AL 102 11 2 New Cottages, Shripney Road Bognor Regis PO22 9PF

However, the application is recommended for refusal on the following grounds:

Title
Plans as Proposed

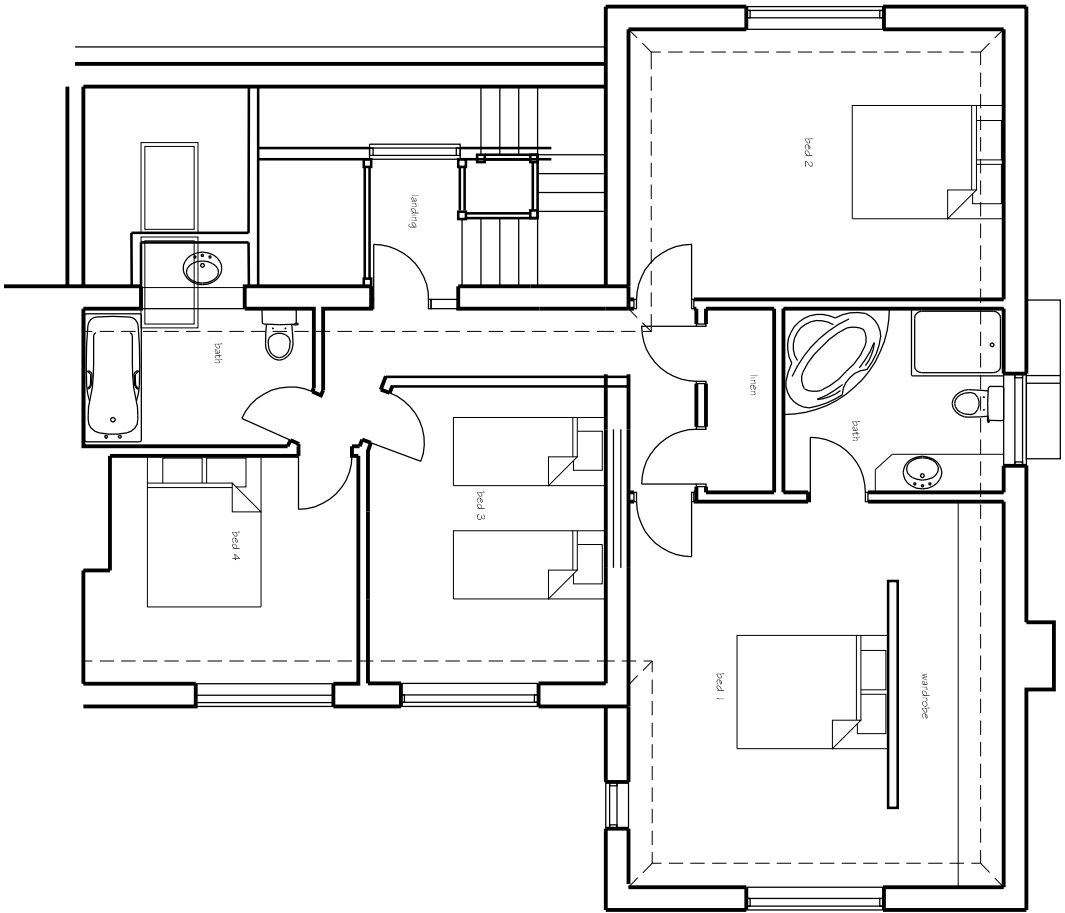
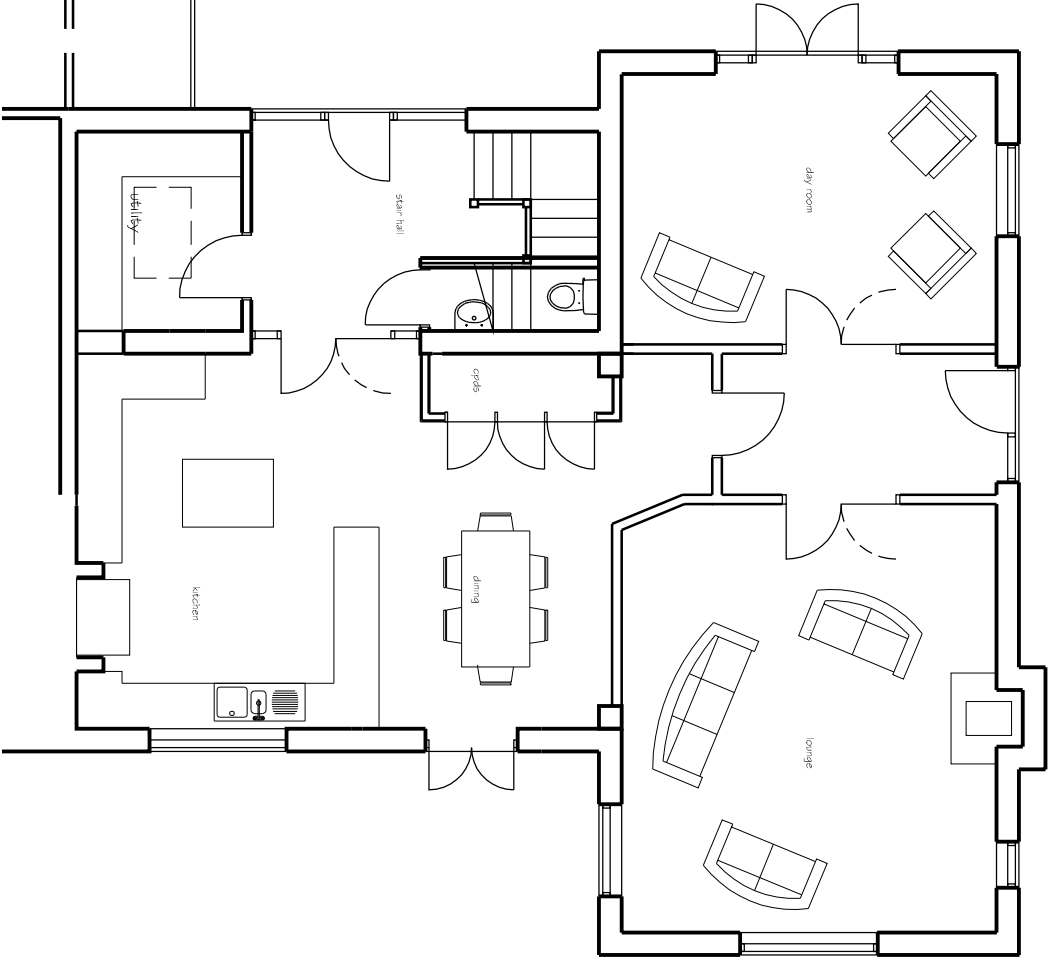
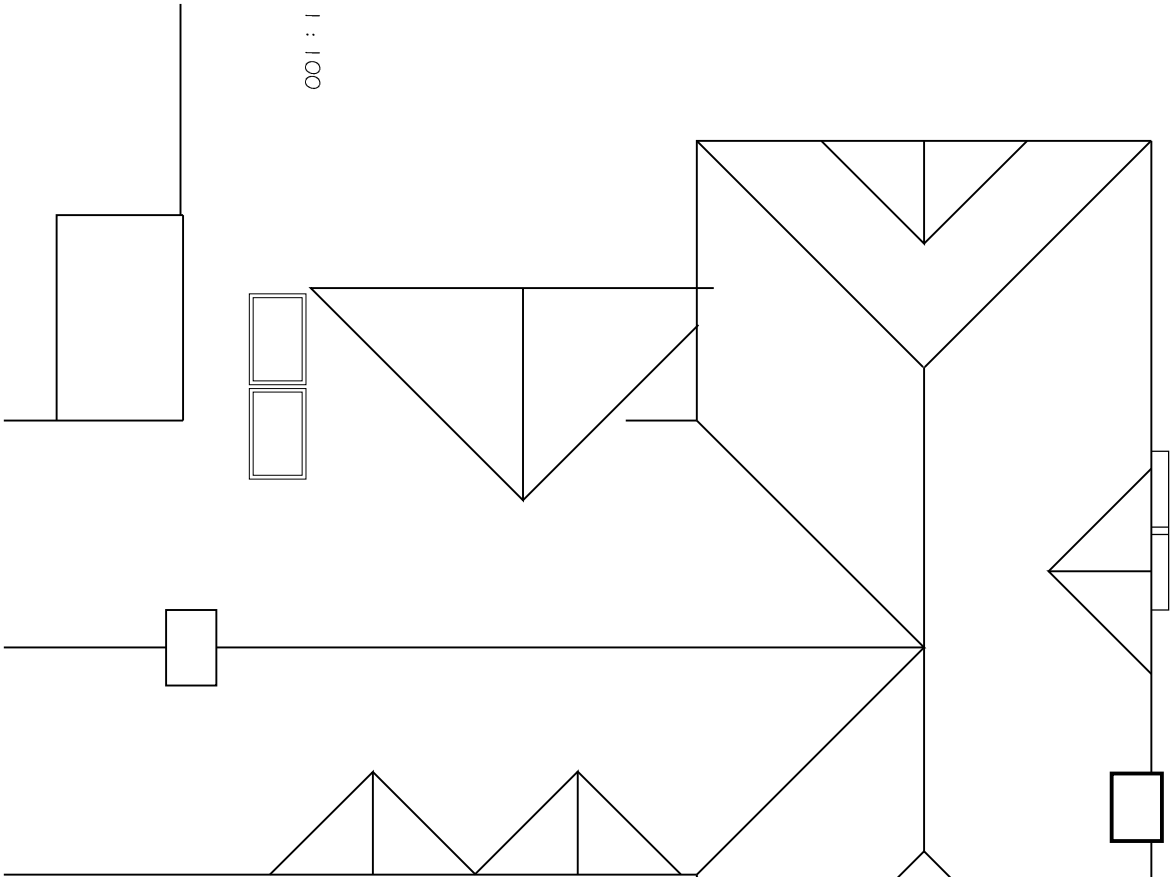
The proposed extensions and alterations, by virtue of their scale, form and massing, are not visually subservient to the dwelling and would be visually intrusive and harmful to the amenities of the surrounding countryside, contrary to policy DEV19 ii) and GEN7 of the Arun District Local Plan and PPS7.
